From: David Petrucci
To: Helen Donaldson
CC: Chris Pirone
Date: 9/4/2014 9:23 AM
Subject: Pamela Rd
Attachments: Pamela Rd.htm

David Petrucci, Fire Captain
Portland Fire Department
Fire Prevention Bureau
380 Congress Street
Portland, Maine 04101

SITE, LAYOUT & UTILITY PLAN

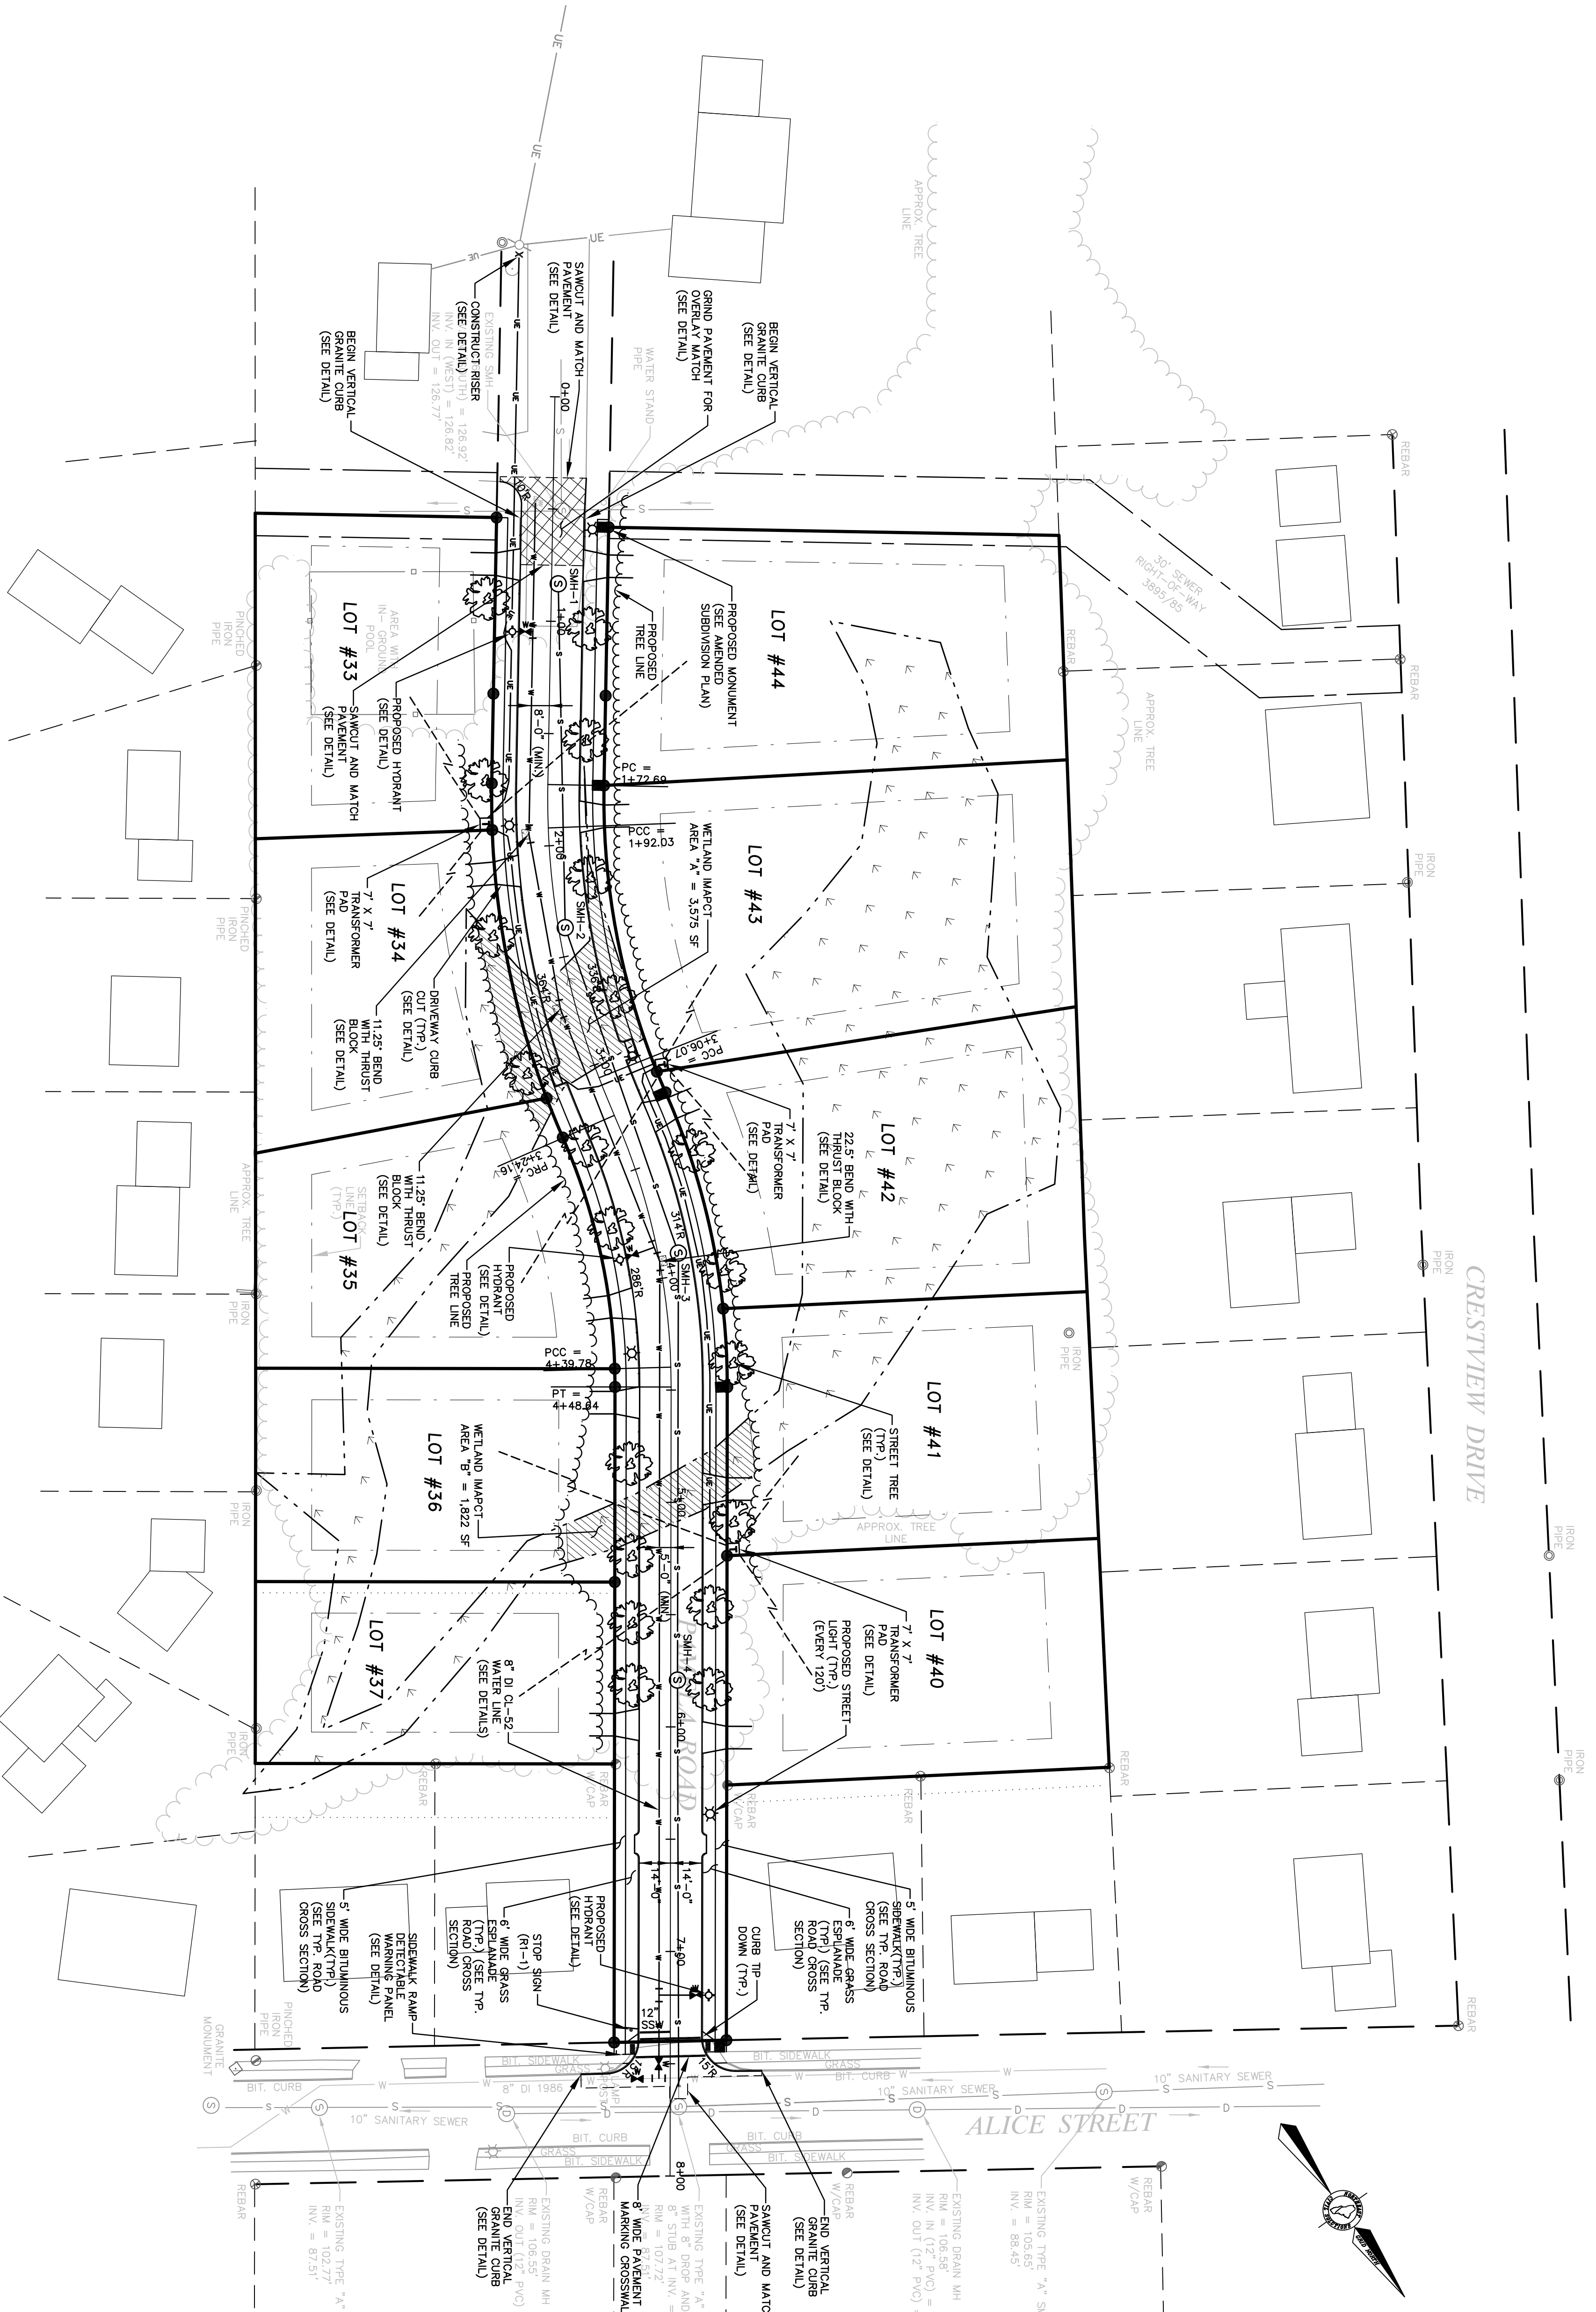
Our comments at this point are that the street needs hydrants, hydrants should be approximately 500 feet apart. There are two hydrants on Alice each approximately 700+/- from where Pamela Rd will intersect. There is also a hydrant around the corner on Abby Ln about 250 ft from Pamela, the next hydrant is up at Crestview. I printed out a GIS with some measurements and markups and will scan that and email it to you.
